Our Ref: LU/46/26/DOC

Approval of details reserved by condition under LU/234/25/PL relating to condition 3- Materials and Finishes.

5 Selborne Place Selborne Road Littlehampton BN17 5NH

Arun District Council have decided to **APPROVE details reserved by this condition**

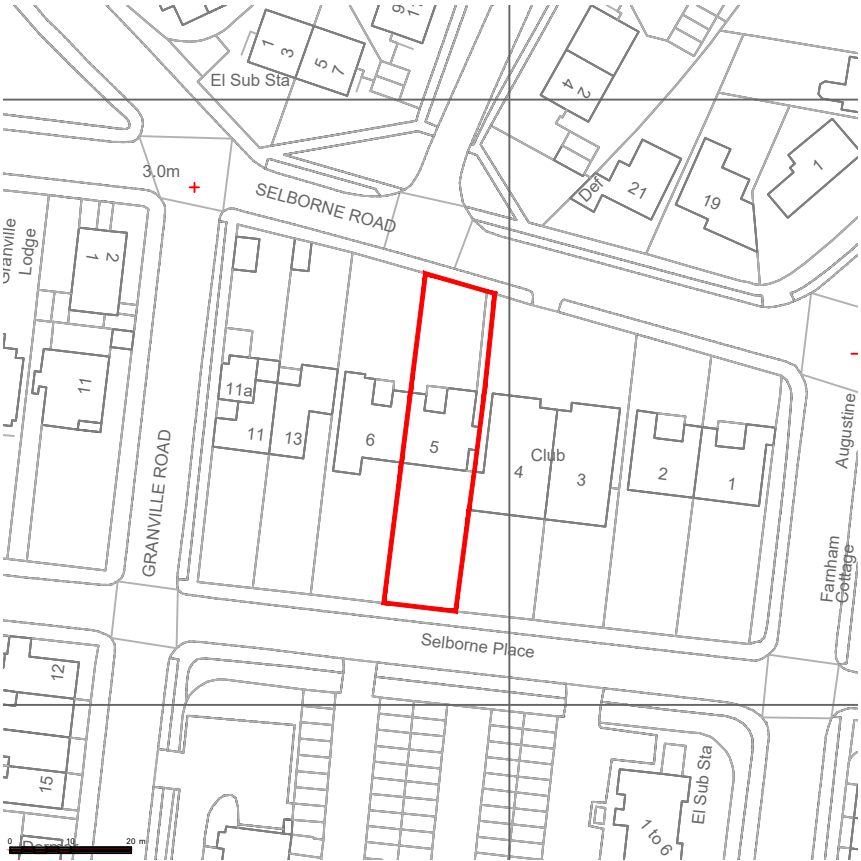
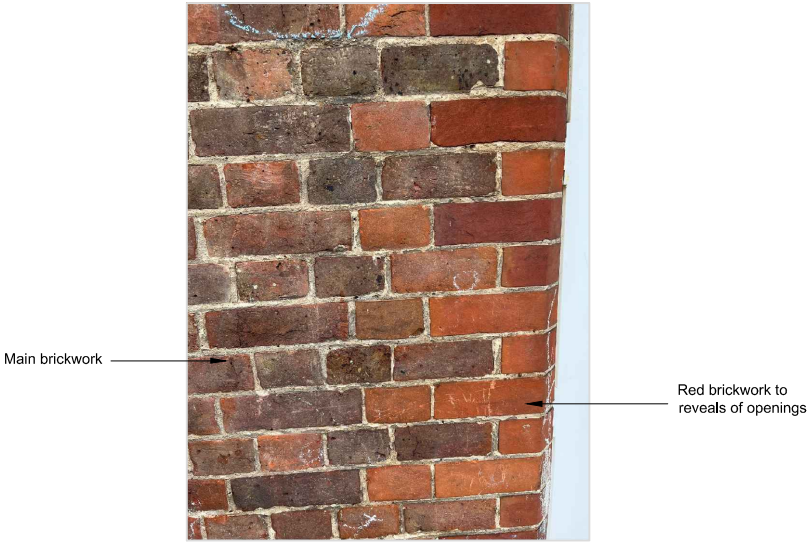
Concerns were raised regarding the thickness and specification of the mortar joints was raised by the Conservation Officer. The agent has submitted further details in this respect. It has been confirmed that the colour, profile and thickness of the mortar will be as close a match as possible (taking guidance from the brick manufacturer) and that a sample panel will be erected on site for review once a builder is appointed. This is acceptable.
